STATE OF NORTH CAROLINA
DEPARTMENT OF TRANSPORTATION

Addendum No. 1

RE: Contract # C204329

I-73/74 FROM SR-1455 TO US-220 IN RICHMOND COUNTY AND
FROM NC-211 TO NC-24/27 IN MONTGOMERY COUNTY.

040397
-5012-MAY-2019-15:09:40
C:\Users\jlsch\OneDrive\Documents\GIS\Montgomery\Richmond Map\2019\FY_2020\MONTGOMERY_RESURFACING-OVERVIEW_MAP.dgn

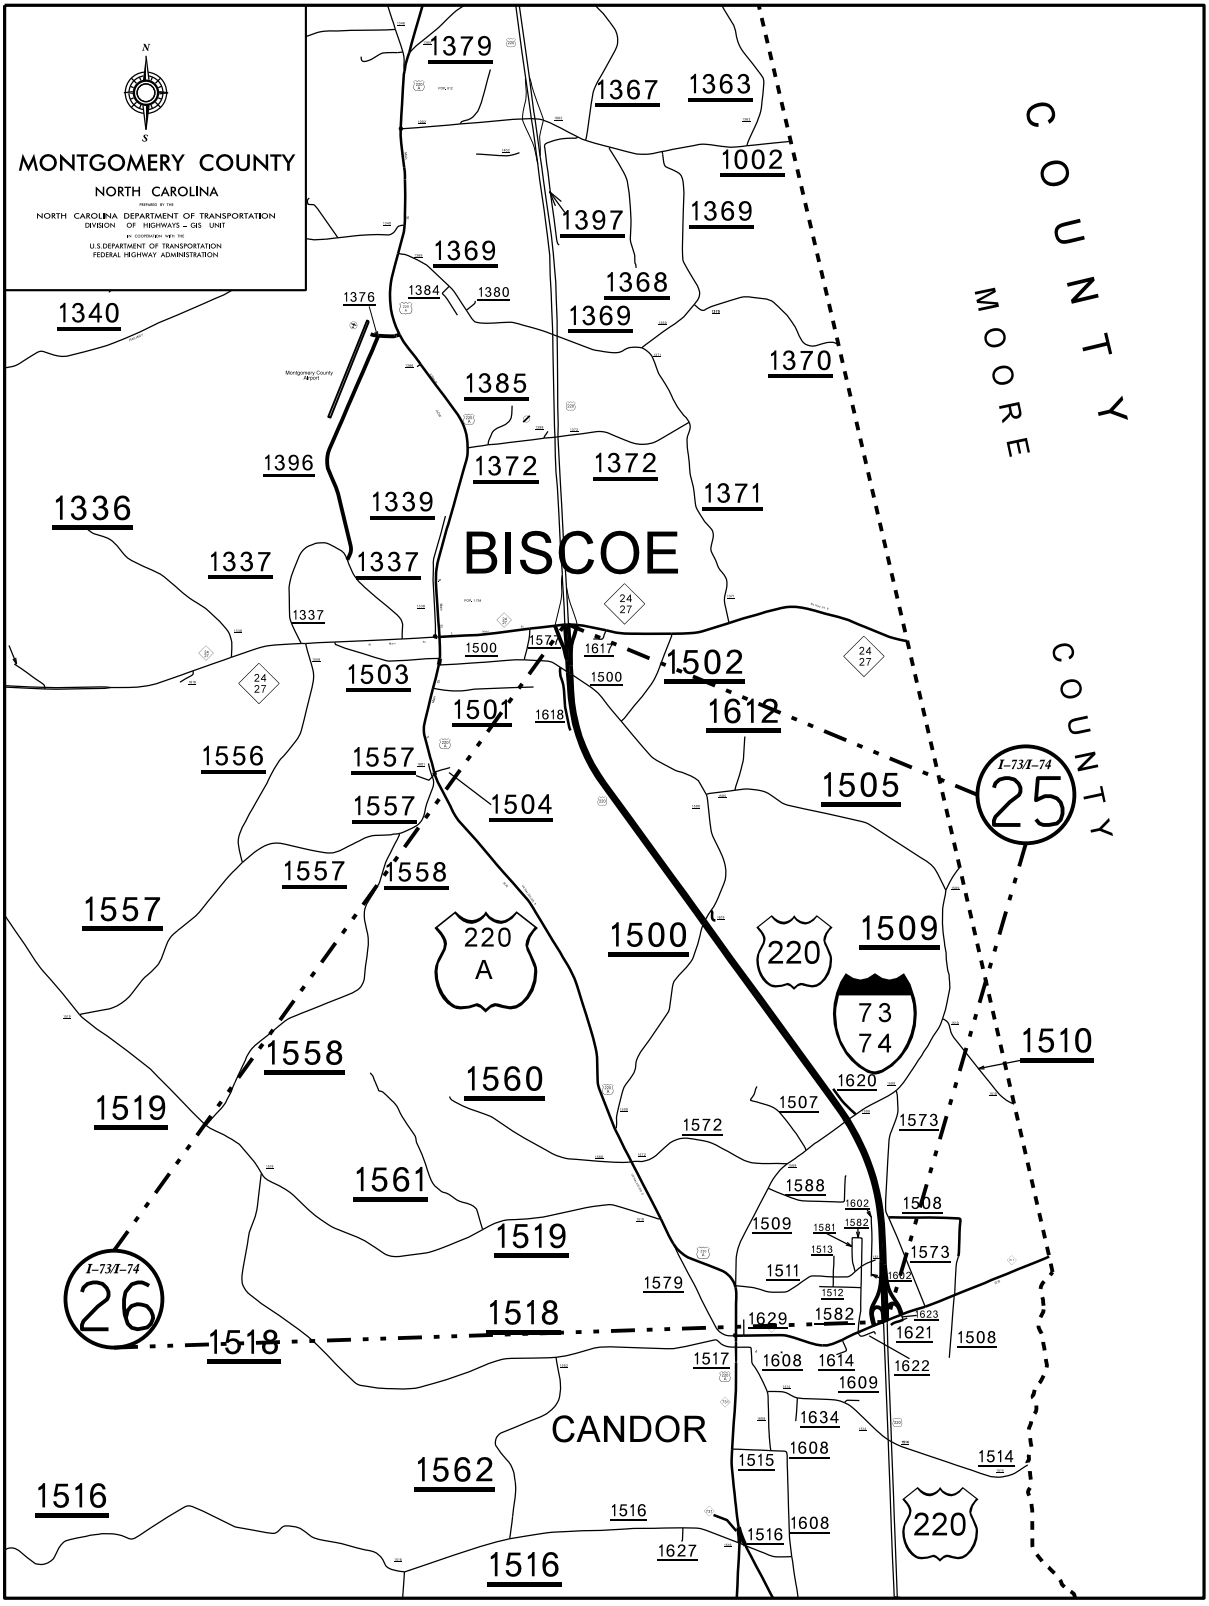
Sheet No.	Revisions
All Sheets	Project Numbers/WBS Numbers have been revised/deleted. Maps 1 thru 22 have been deleted from this project.

Please discard all previous sheets and refer to new Sheets 1 thru TMP-1.
